Re: **Marysville Corporate Center**
Preliminary Binding Site Plan – PA22004
Project Number 2200444.00

In response to your plan review checklist dated April 28, 2022, we have addressed the items below, with our responses following your comments.

INDEX DATA: SEC 28-33 T 31N R 5E WM
SURVEY FOR: PACIFIC REALTY ASSOCIATES, L.P. 15908 47TH AVE NE MARYSVILLE, WA 98271
SNOHOMISH COUNTY, WASHINGTON
SHEET 2 OF 8

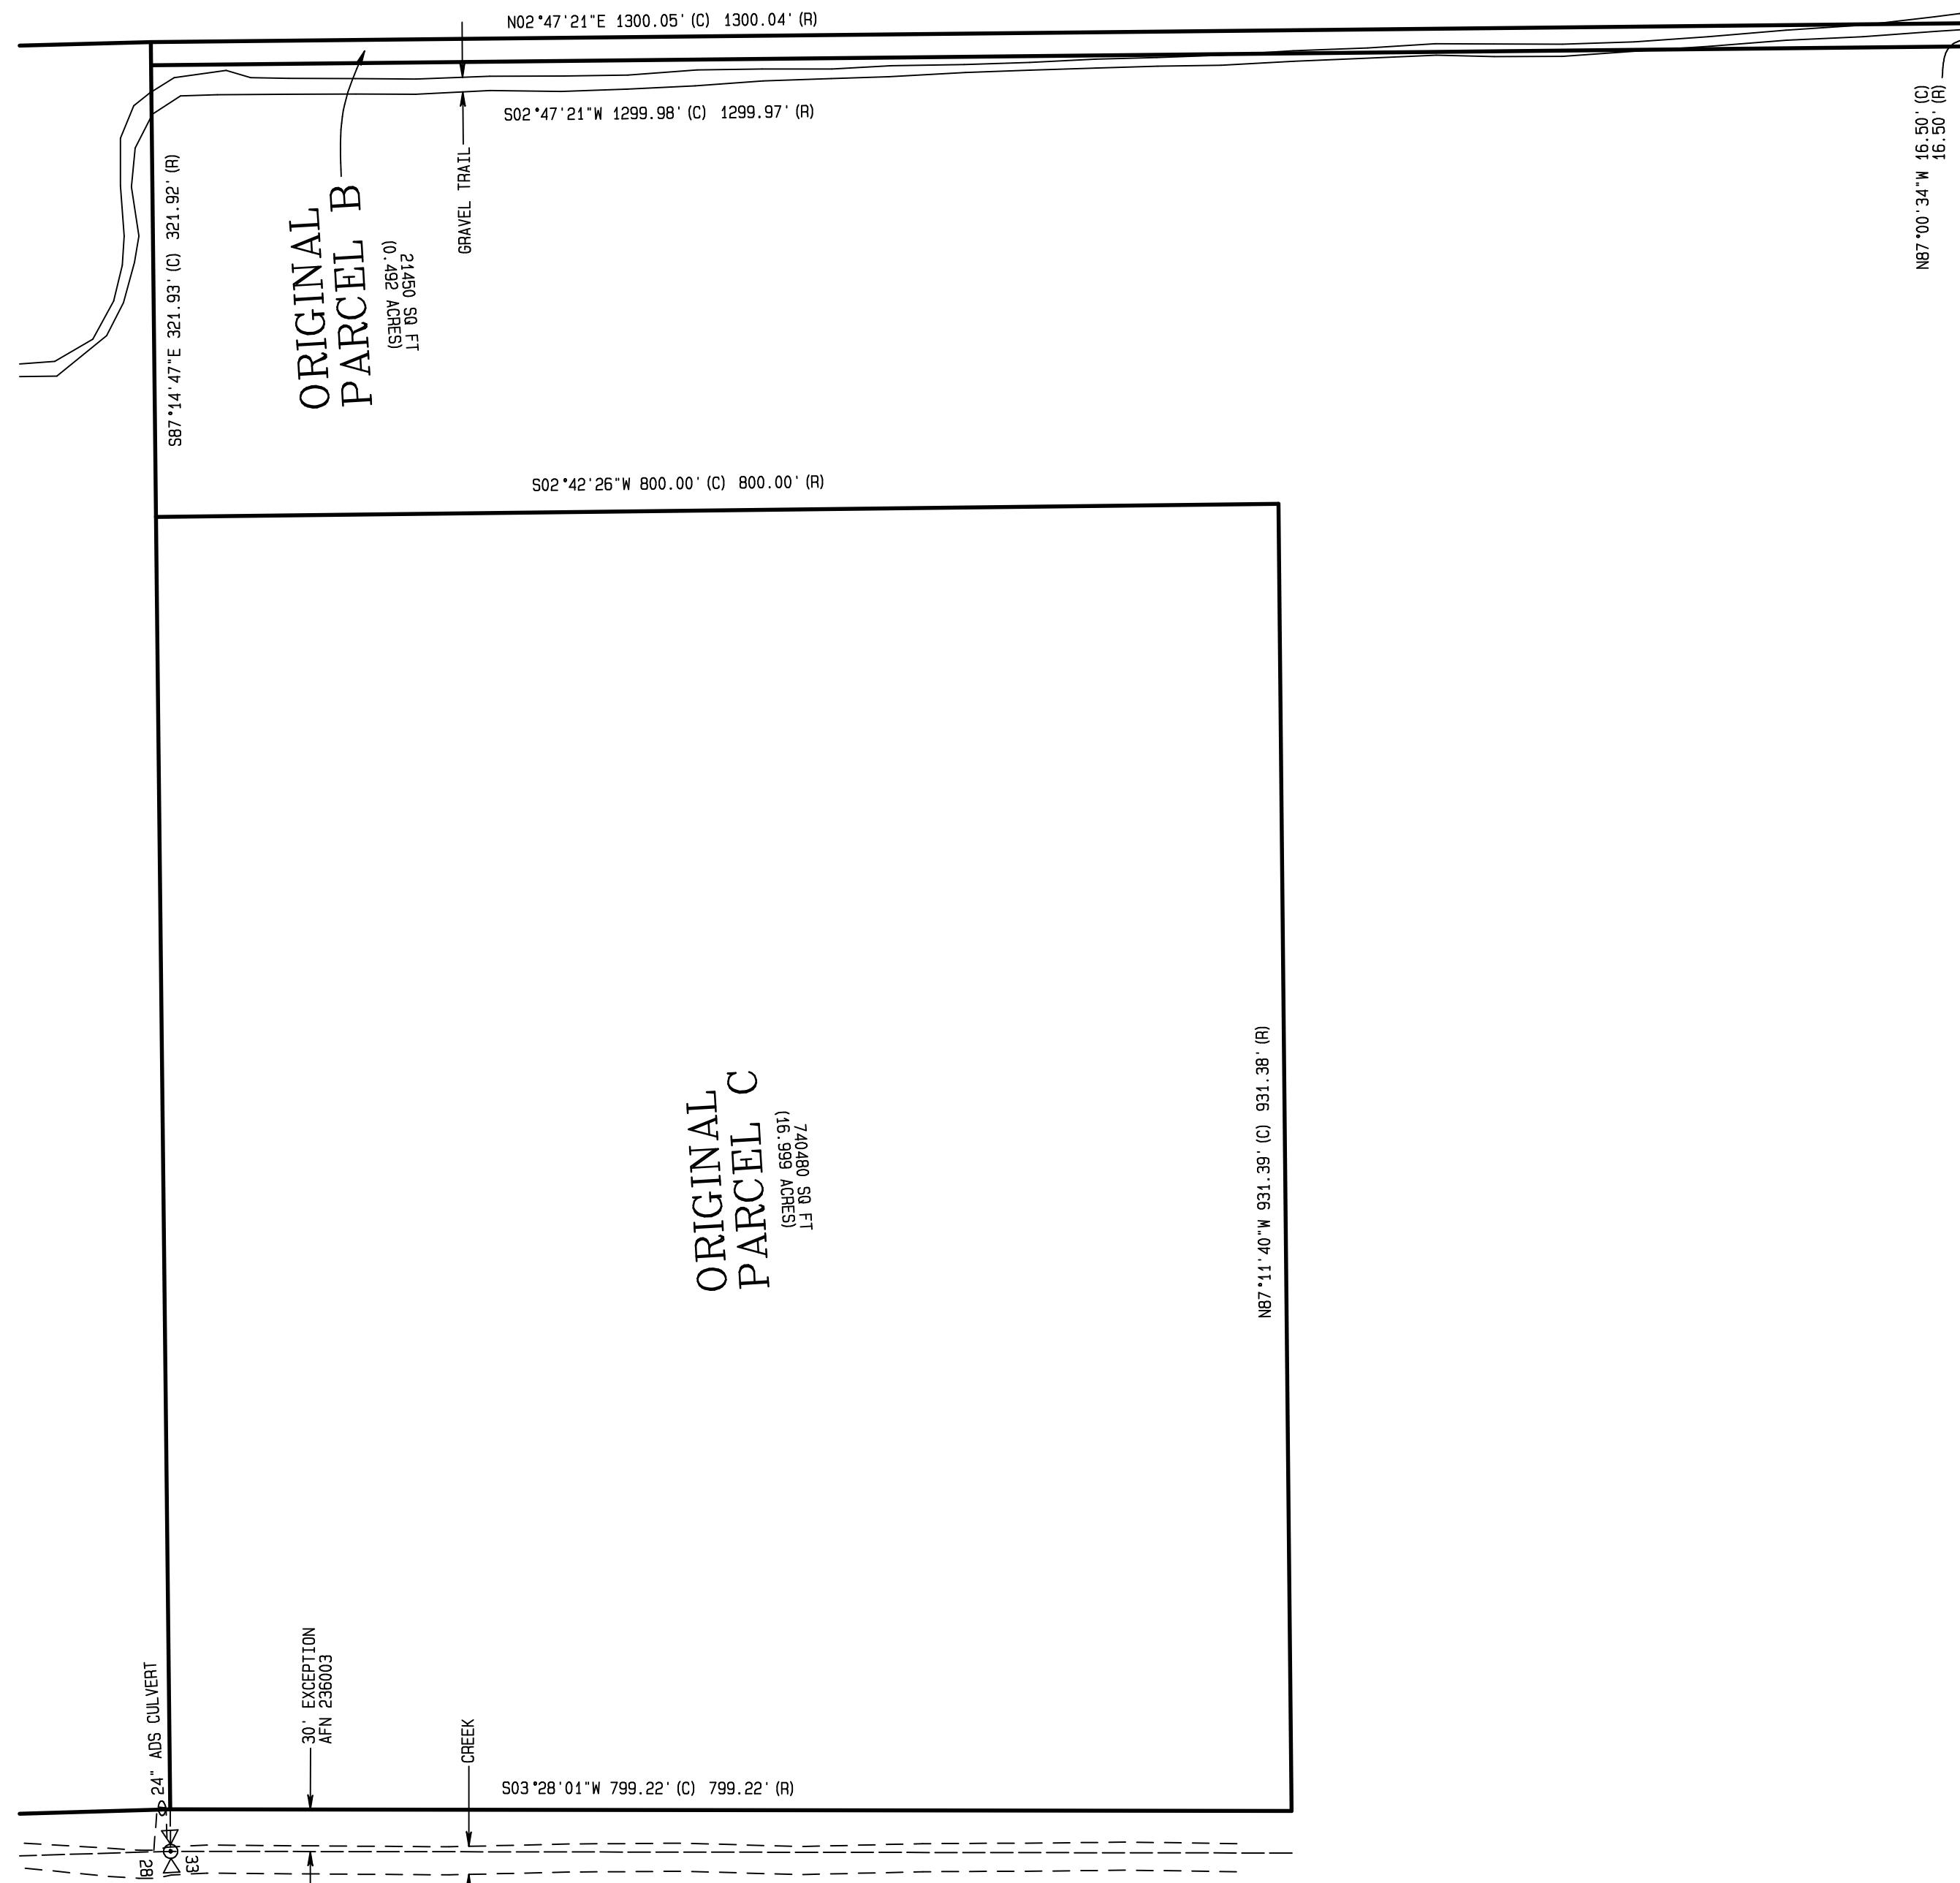
- g. *Provide a "ZONING COMPLIANCE" section demonstrating compliance with the LI bulk & dimensional standards outlined in MMC 22C.020.080(2)*

- h. *Provide a "PARKING COMPLIANCE" section demonstrating compliance with:*

Response: Sheet 2 of 6 provides zoning compliance.

Response: Parking compliance is shown on sheet 2 of 6 for the entire BSPE.

EXISTING CONDITION

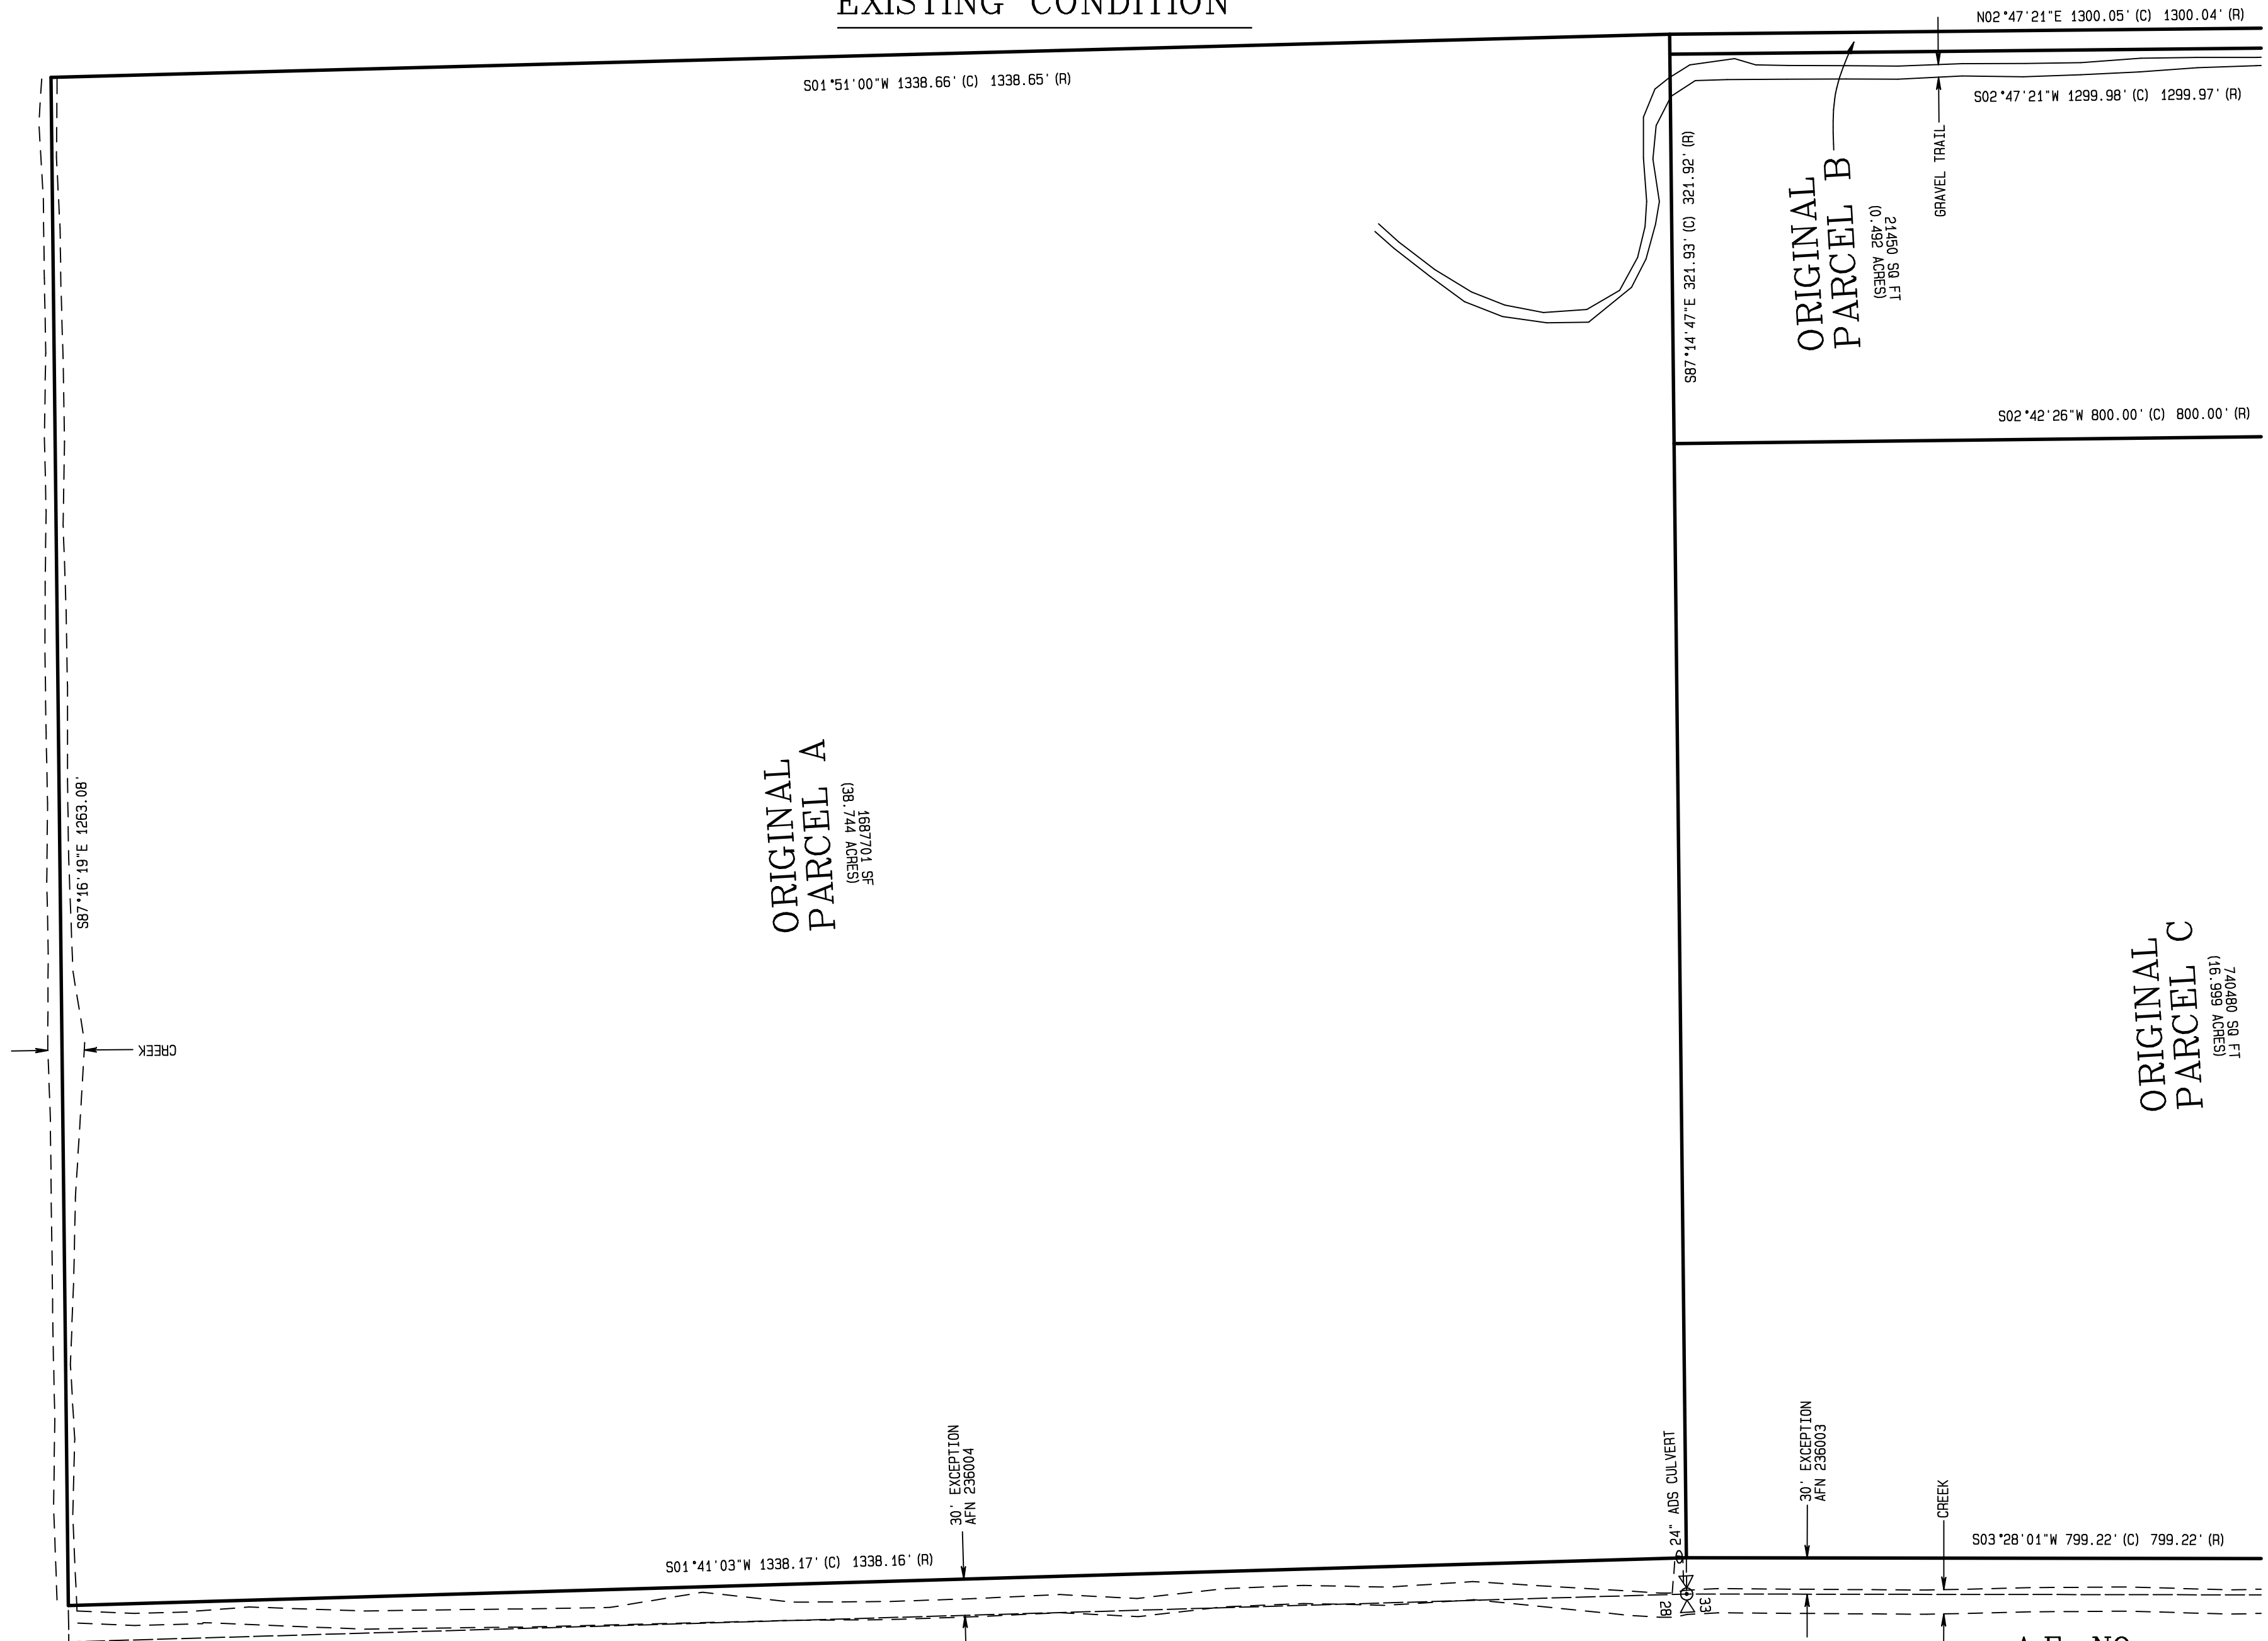
- f. *An existing conditions sheet will need to be provided, which depicts all encumbrances outlined in Schedule B of the Title Report prepared by Chicago Title Insurance Company, dated February 24, 2022. If the encumbrances cannot be depicted they shall be referenced.*

Response: An existing conditions sheet has been added to the preliminary BSP; see sheets 2 and 3 or 8.

SHEET 6 OF 8

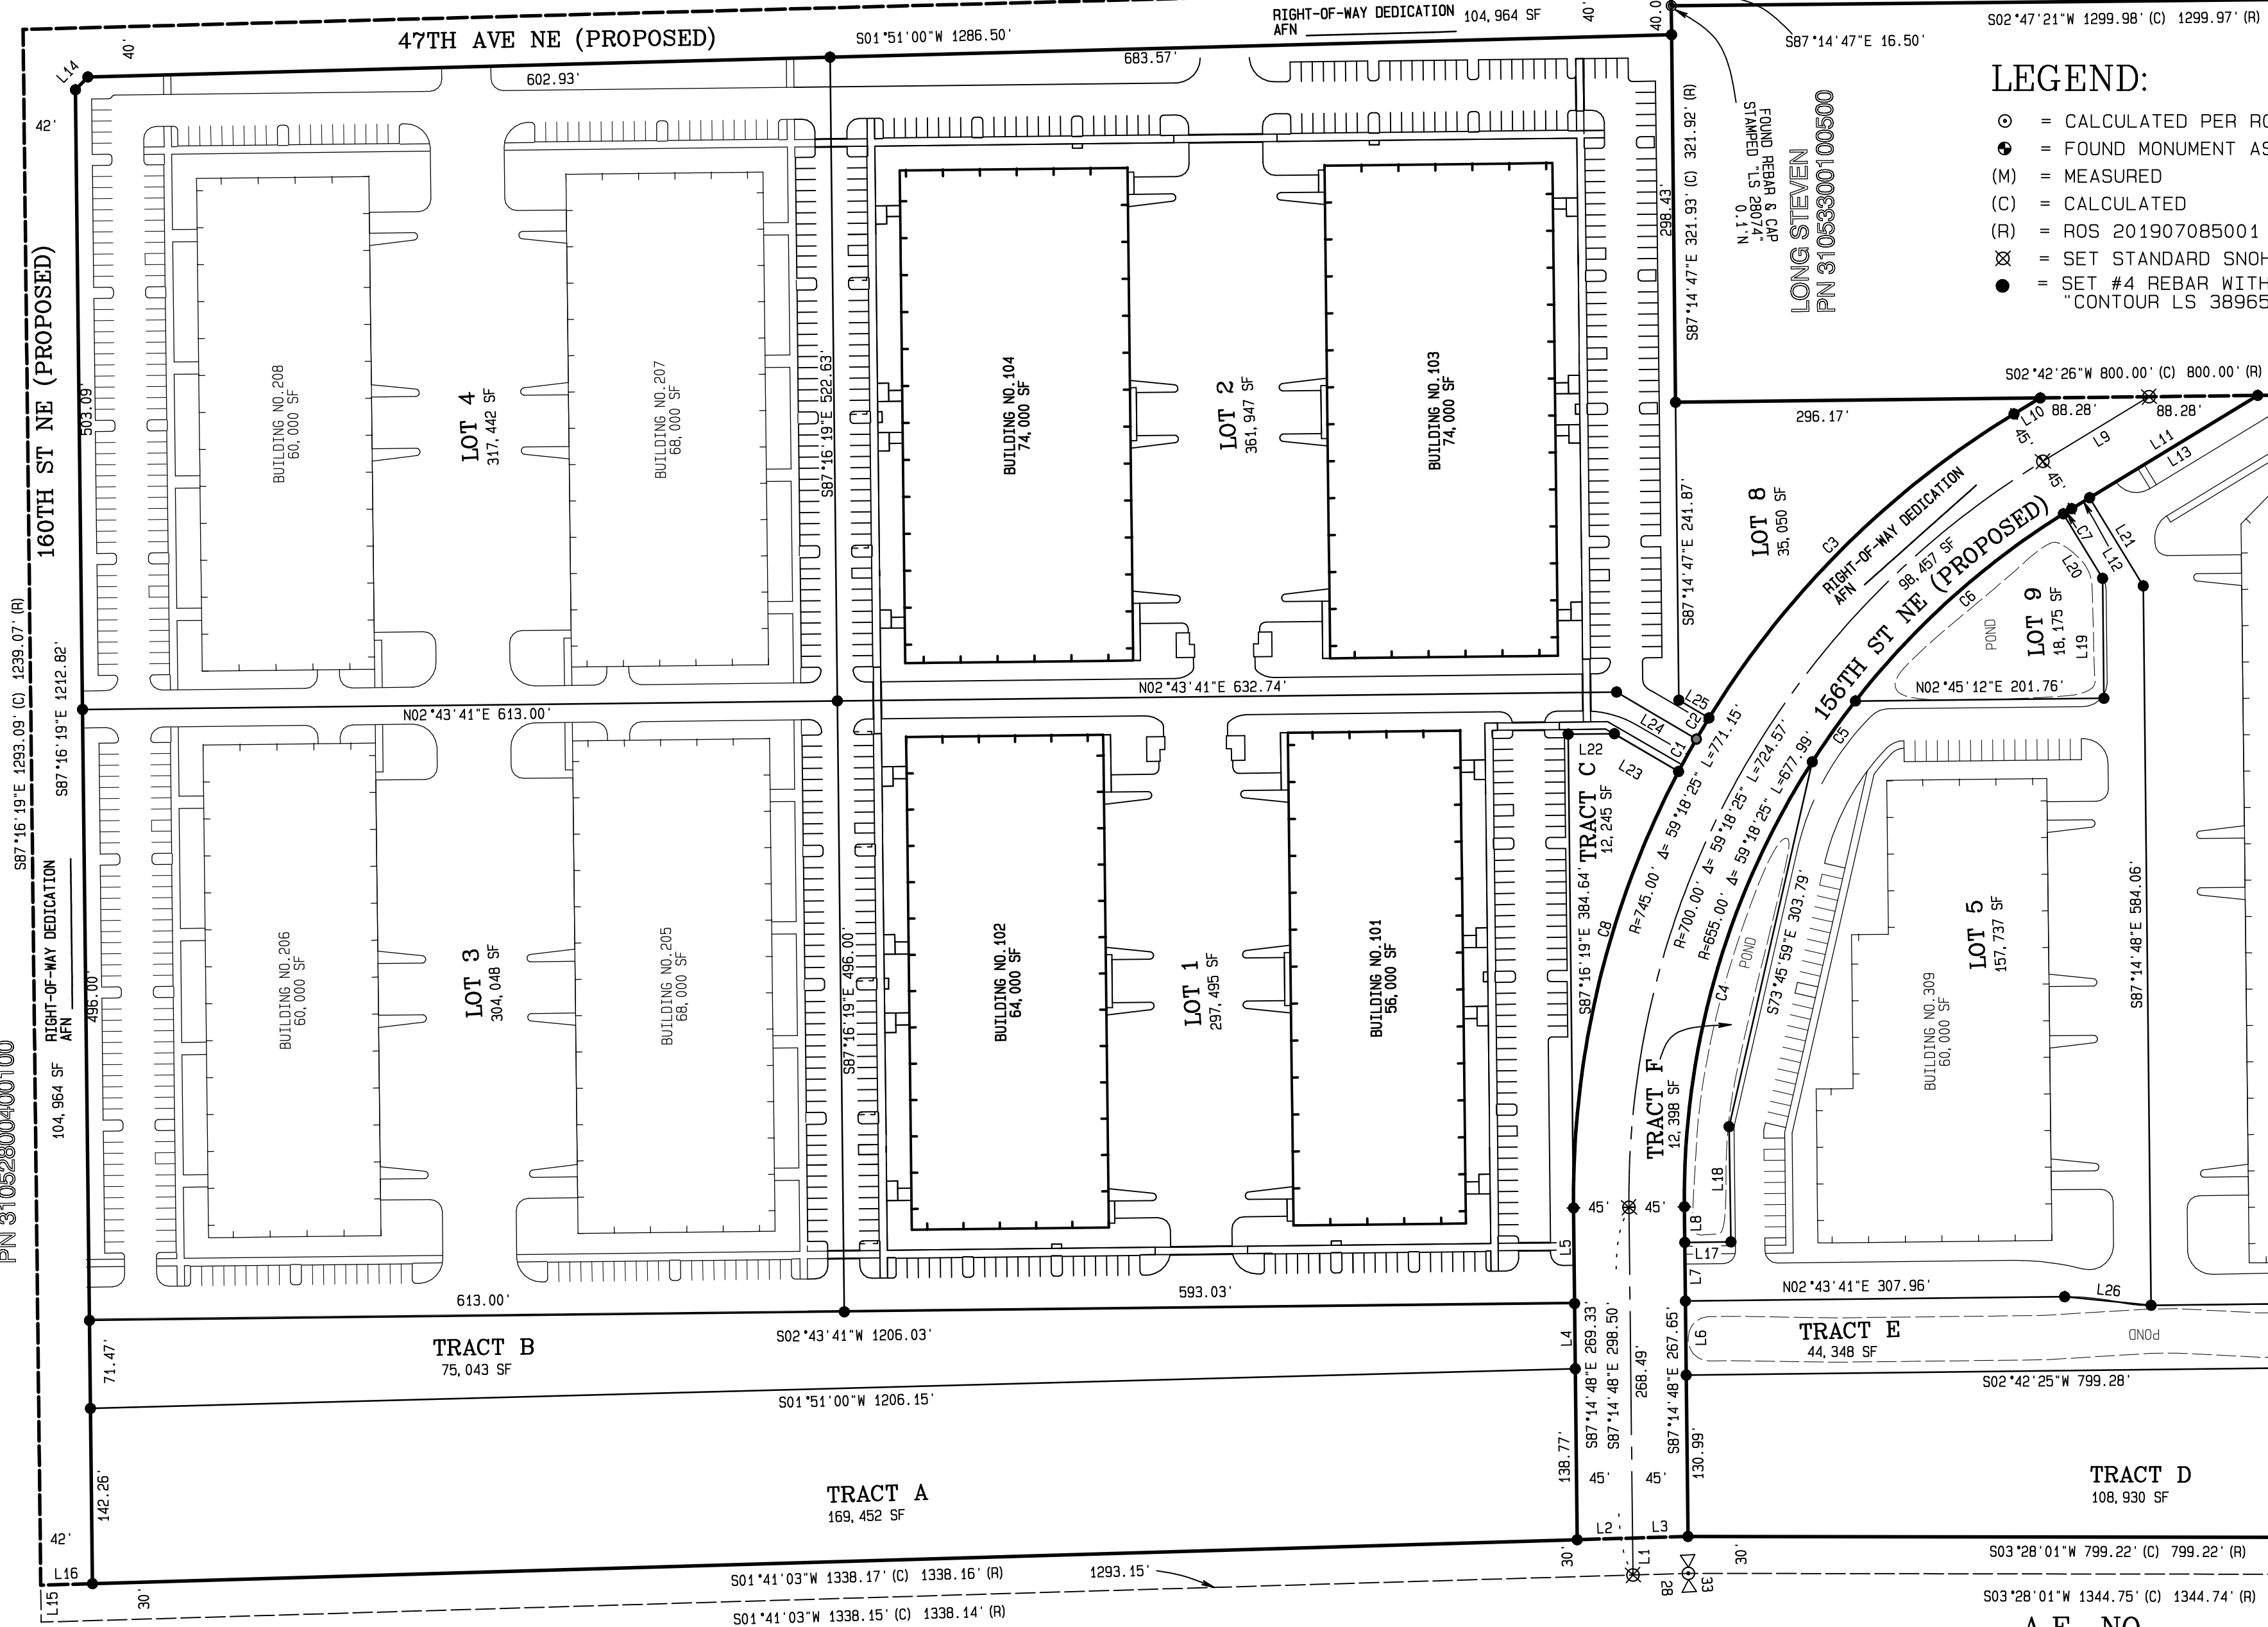
- d. *Phase 1, including all lots and tracts for all phases, shall be drawn with dark solid lines. With the recording of Phase 1 all lots will be created, however, individual site plan review will be required for development of subsequent phases.*

Response: As shown on sheet 4 or 6, Phase I is a draft solid line and future phases are shown as a greyed out line. We understand future phases will require individual site plan review.
